SCHEDULE OF PLANNING REVISIONS FOR NMA

PROJECT **higgi haus - 57-59 St Mary's Street Cardiff**
 ISSUE DATE **18/12/2023**
 REVISION

PROPOSED GA ELEVATION - NORTH

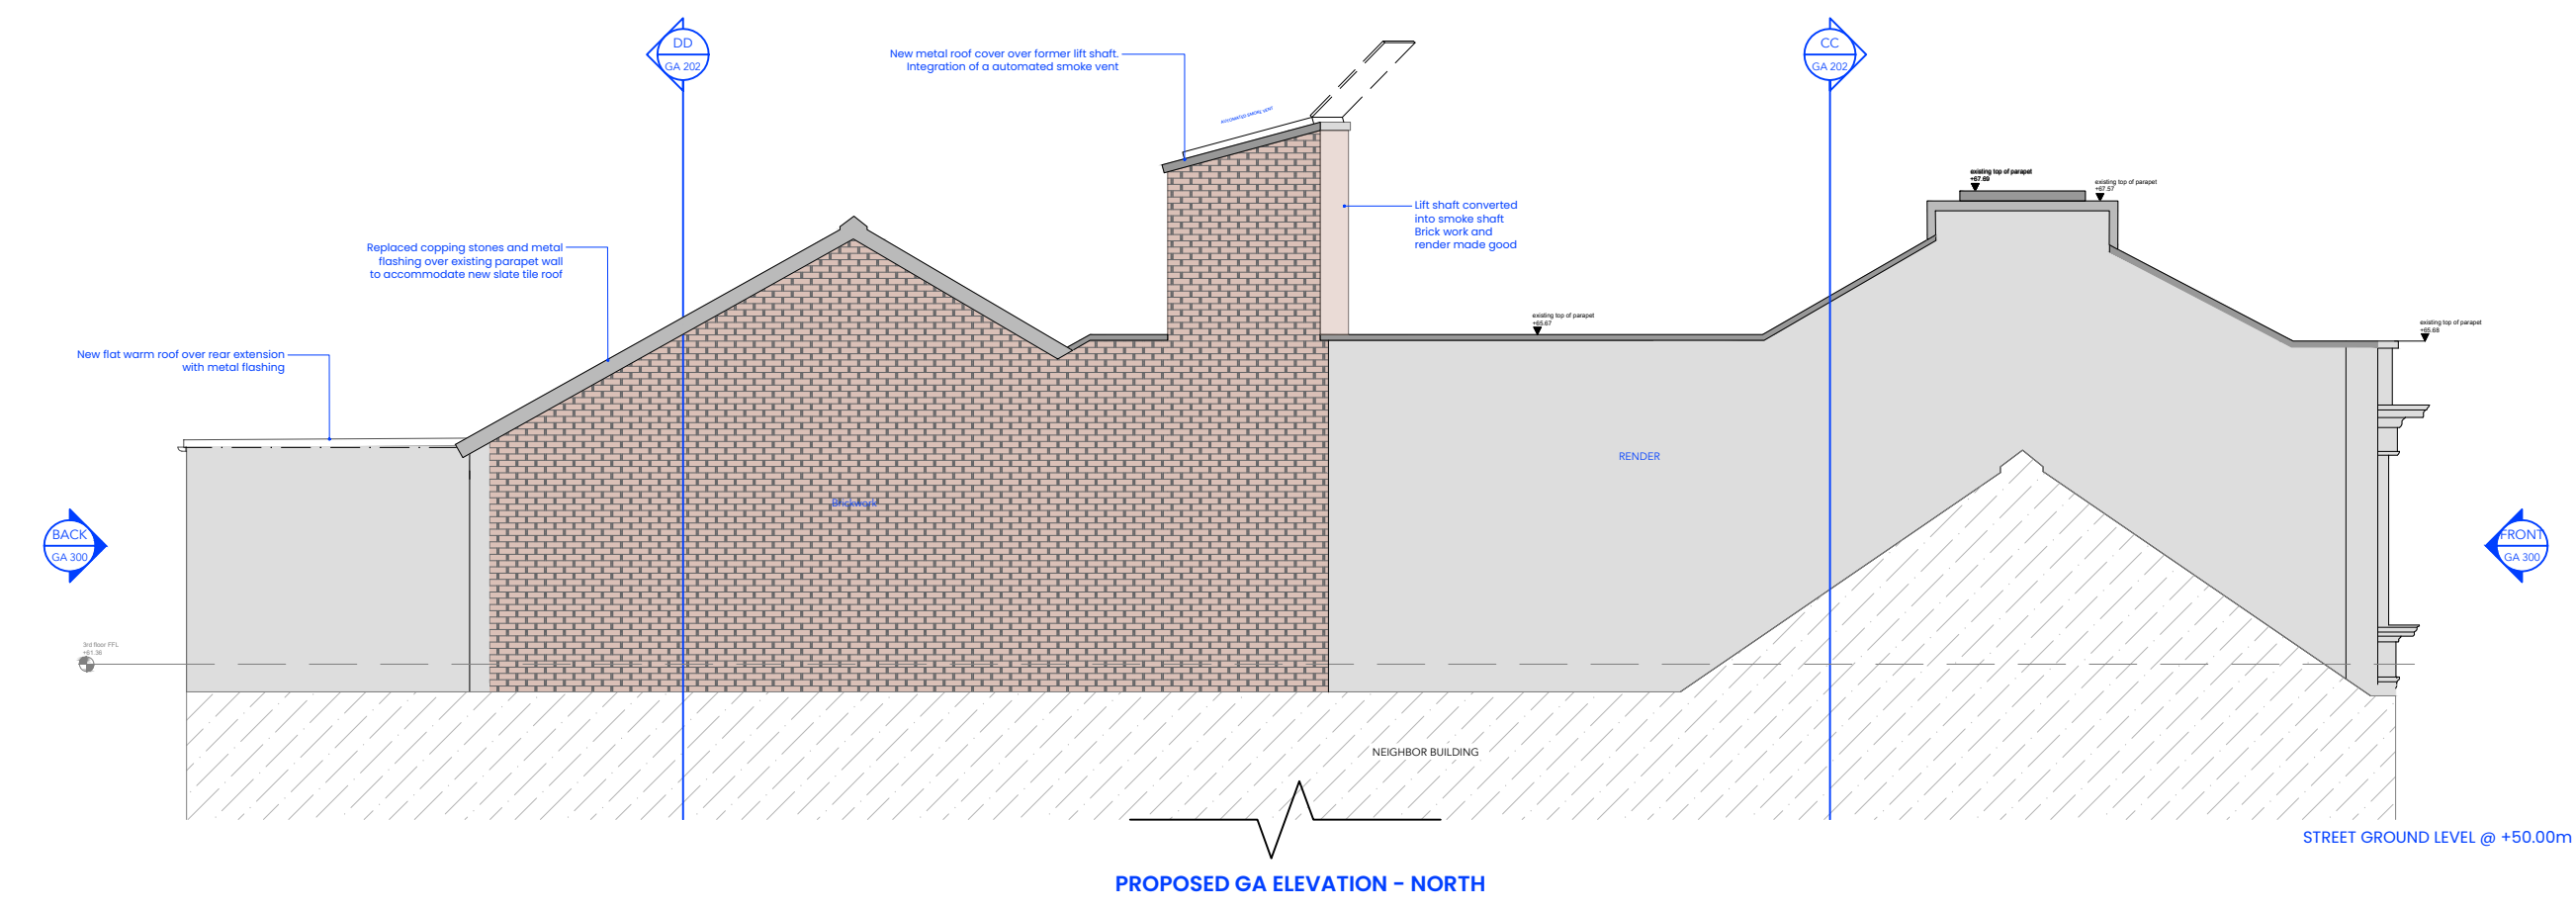
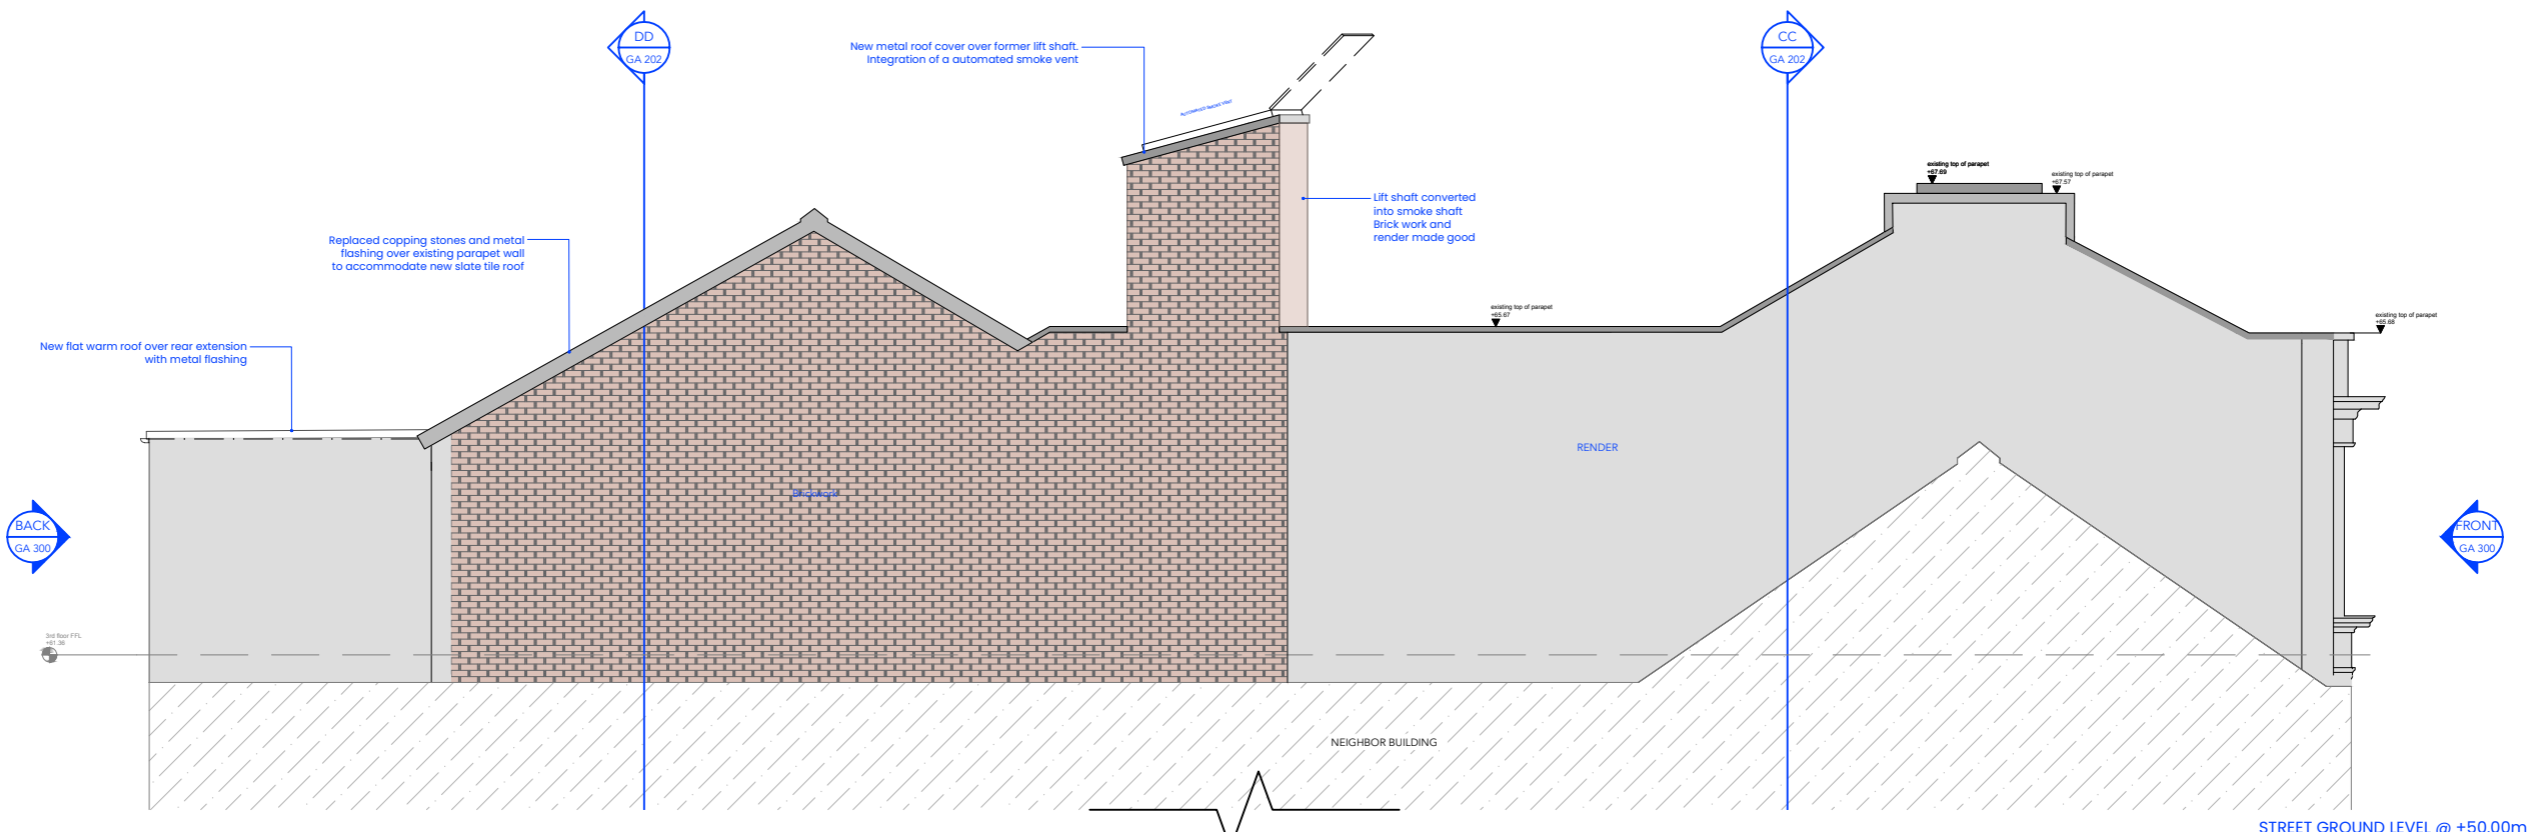
Page 10	JHHSMS/019/P1	Existing & Proposed North Elevation	PI 04.04.22 Planning Application Issue	HH ST GA 301	SOUTH AND NORTH ELEVATIONS GA PROPOSED	NMA Issue 12/12/23	1	Removed proposed mansard roof extension
							2	Removed proposed mansard roof extension - Replacing of existing corrugated roof cover for slate tiles
							3	Removed roof and parapet extension Replaced coping stones and waterproofing
							4	Replacing of the existing corrugated roof over former liftshaft over run for the integration of a automated smoke vent

HH SS GA 103 PLAN-L2

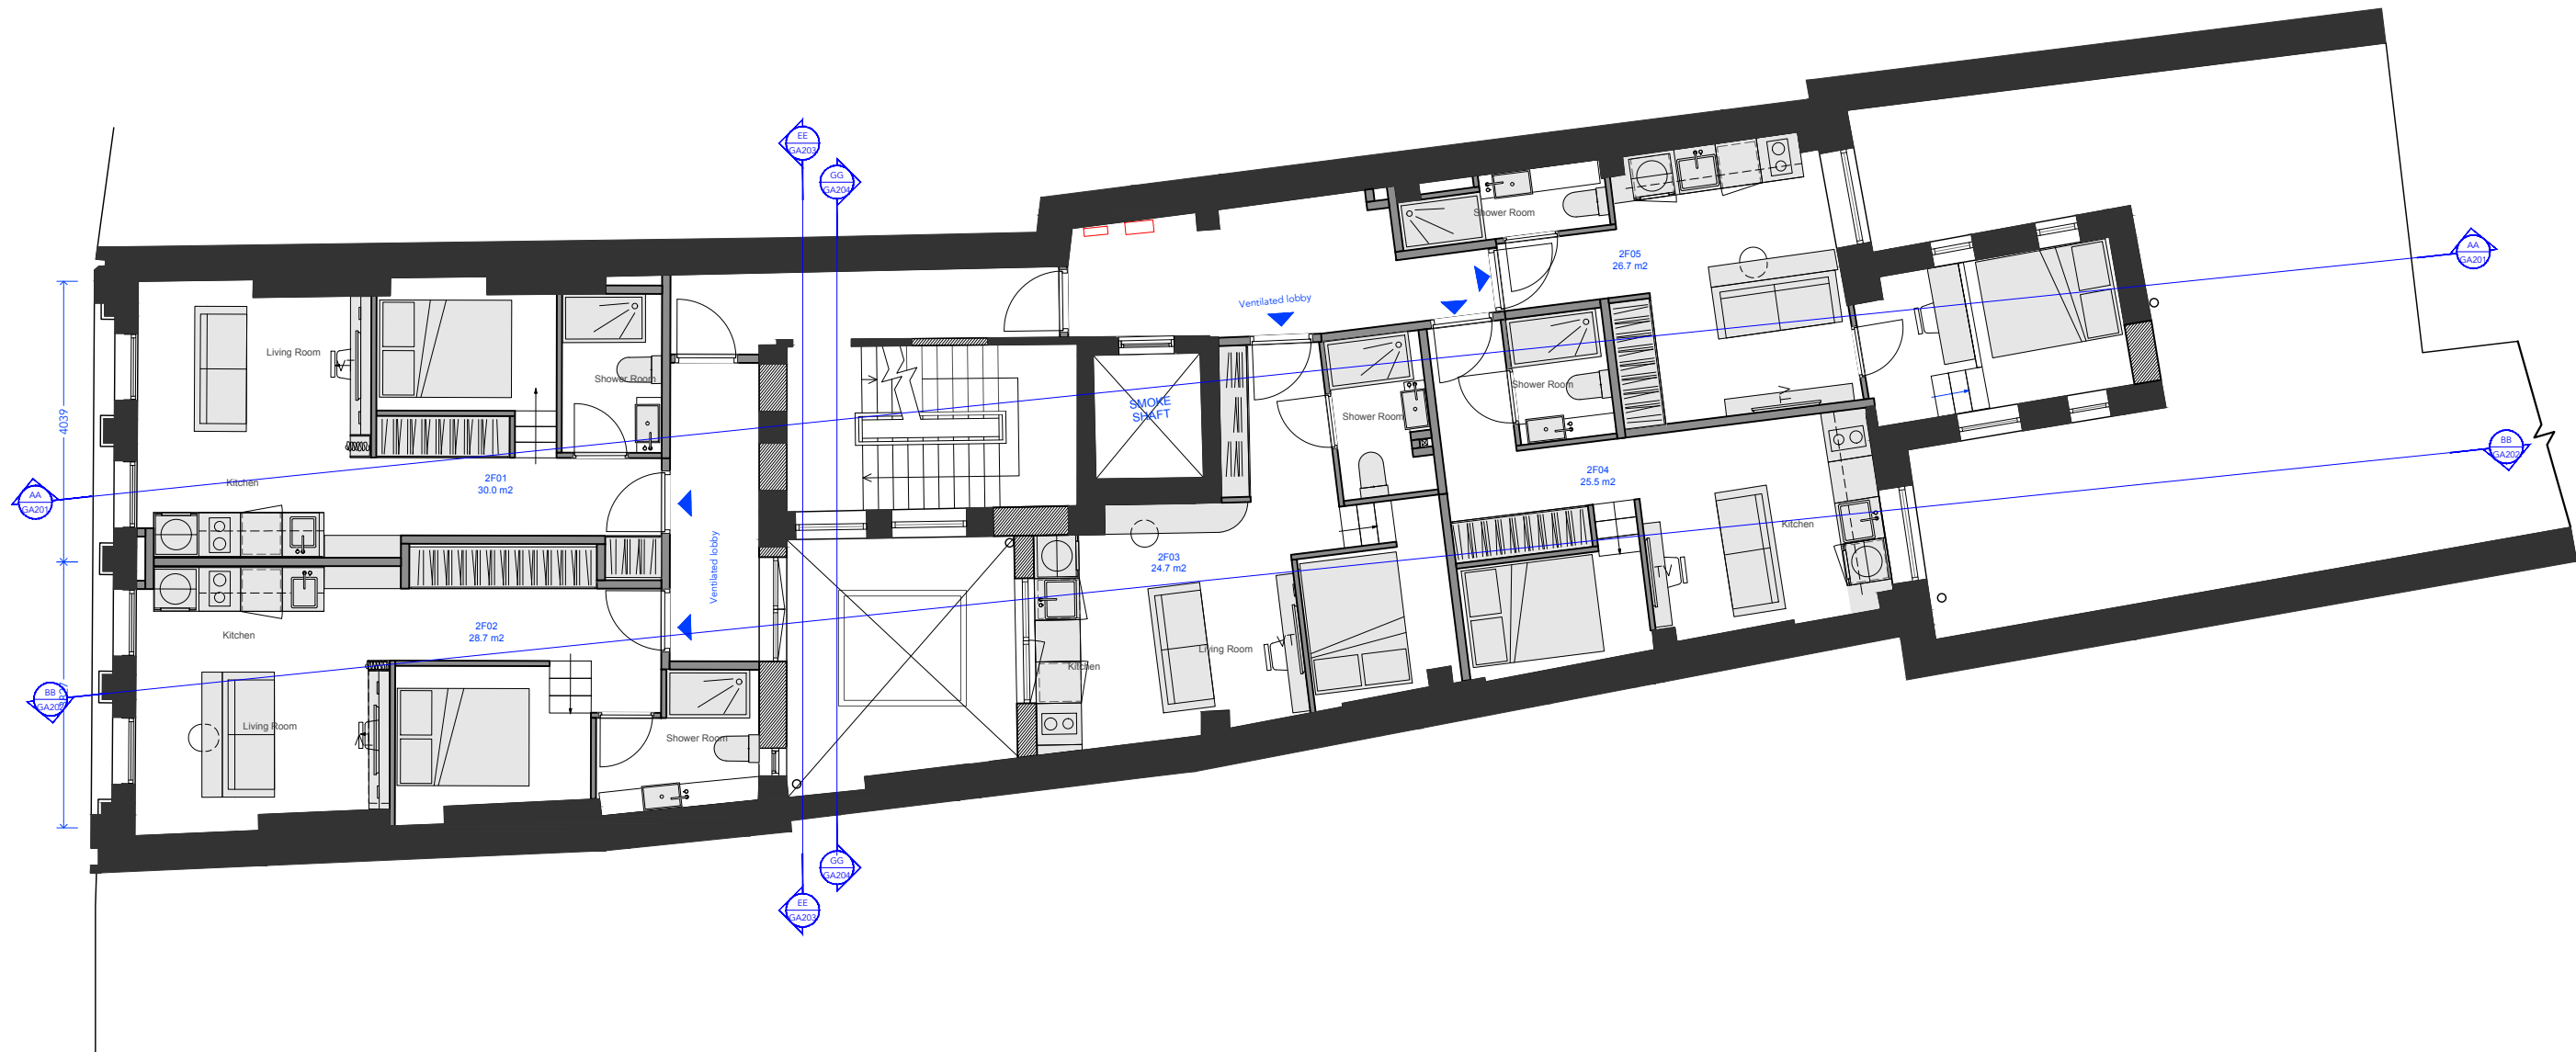
5	New lightwell skylight
							6	General revision of internal layout to accommodate 3 residential unit (previously 2)
							7	General revision of internal layout
							8	Removal of existing external metal stairs at rear of building Kitchen relocated and replaced with bedroom + study
							9	Infill of stairwell windows
Page 05	JHHSMS/012/P3	Third Floor GA Proposal	P3 04.10.21 Planning Application Issue	HH SS GA 104 PLAN-L3	THIRD FLOOR PROPOSED GA PLAN	NMA Issue 12/12/23	1	Removal of proposed new residential lift. Existing empty lift shaft to be converted into emergency smoke shaft.
							2	Window infilled to unable lightwell extension
							3	Suppression of balcony New proposed 8.5sqm extension into lightwell (applicable to 1st, 2nd and 3rd floor)
							4	Suppression of balcony Adjustment of window layout to allow bathroom extension of 1F02 into ventilated lobby whilst maintaining minimum 1.5sqm automated smoke vent window.

HH SS GA 104 PLAN-L3

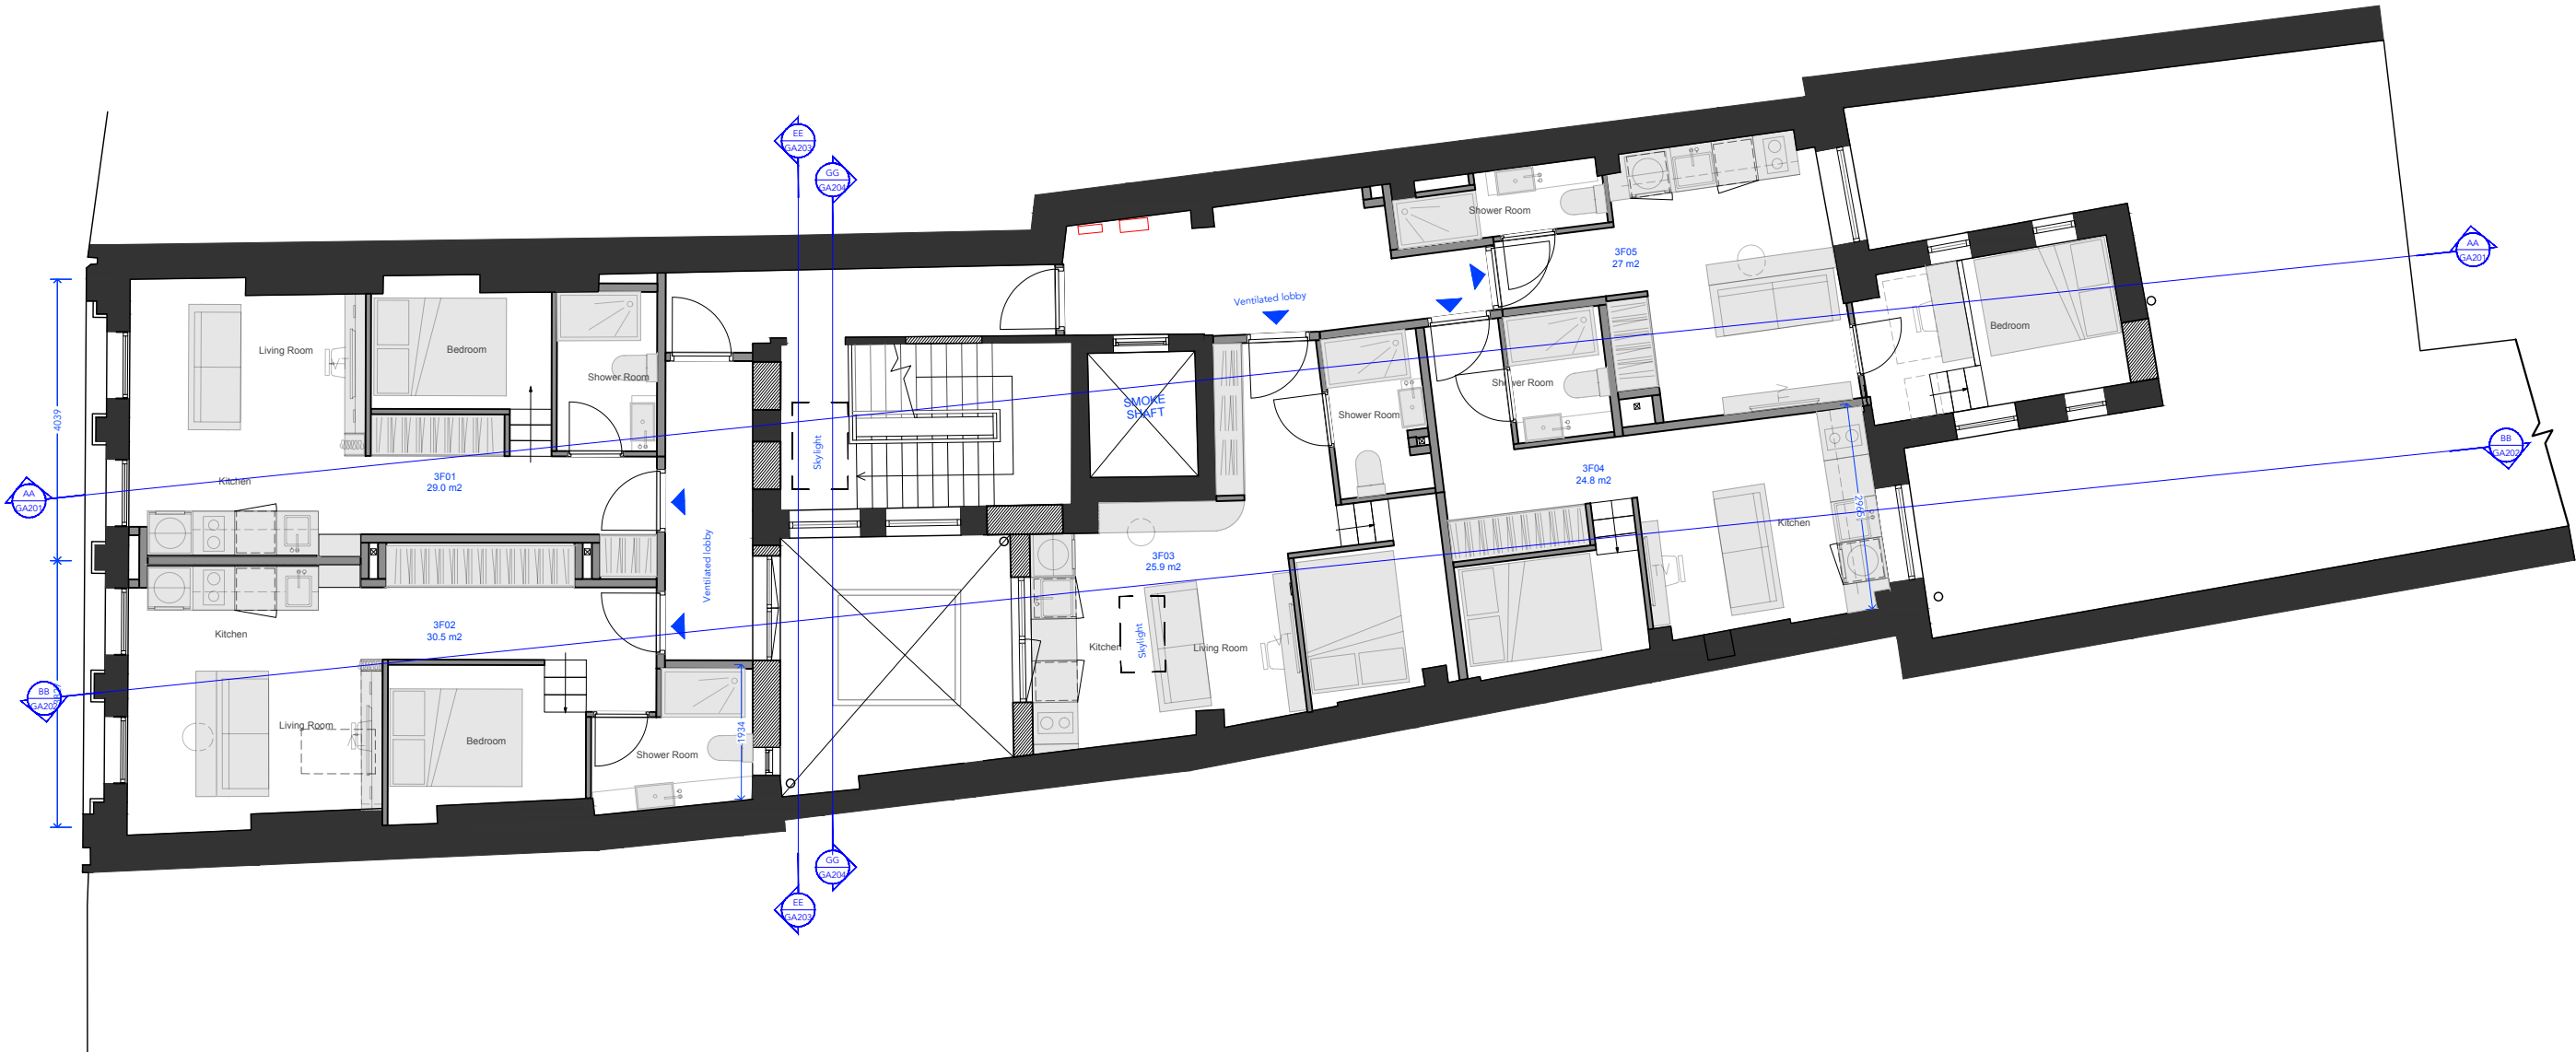
5	New lightwell skylight
							6	General revision of internal layout to accommodate 3 residential unit (previously 2)
							7	General revision of internal layout
							8	Removal of existing external metal stairs at rear of building Kitchen relocated and replaced with bedroom + study
							9	Infill of stairwell windows
Page 06	JHHSMS/013/P3	Fourth Floor GA Proposal	P3 04.10.21 Planning Application Issue	HH SS GA 105 ROOF PLAN	ROOF PROPOSED GA PLAN	NMA Issue 12/12/23	1	Fourth floor roof mansard extension removed - New rear roof cover
Page 07	JHHSMS/015/P4	Proposed Exterior Elevation	P4 04.04.21 Planning Application Issue	HH ST GA 300	FRONT AND REAR ELEVATIONS PROPOSED GA	NMA Issue 12/12/23	1	Added timber faced pillaster to match rythme of split front fascia above
	JHHSMS/018/P1	Existing & Proposed Roof Section/Elevation	PI 04.04.22 Planning Application Issue				2	Relocation of co-working space entrance for seperarated residential entrance + Reinstatement of a central double galzed door to shopfront façade
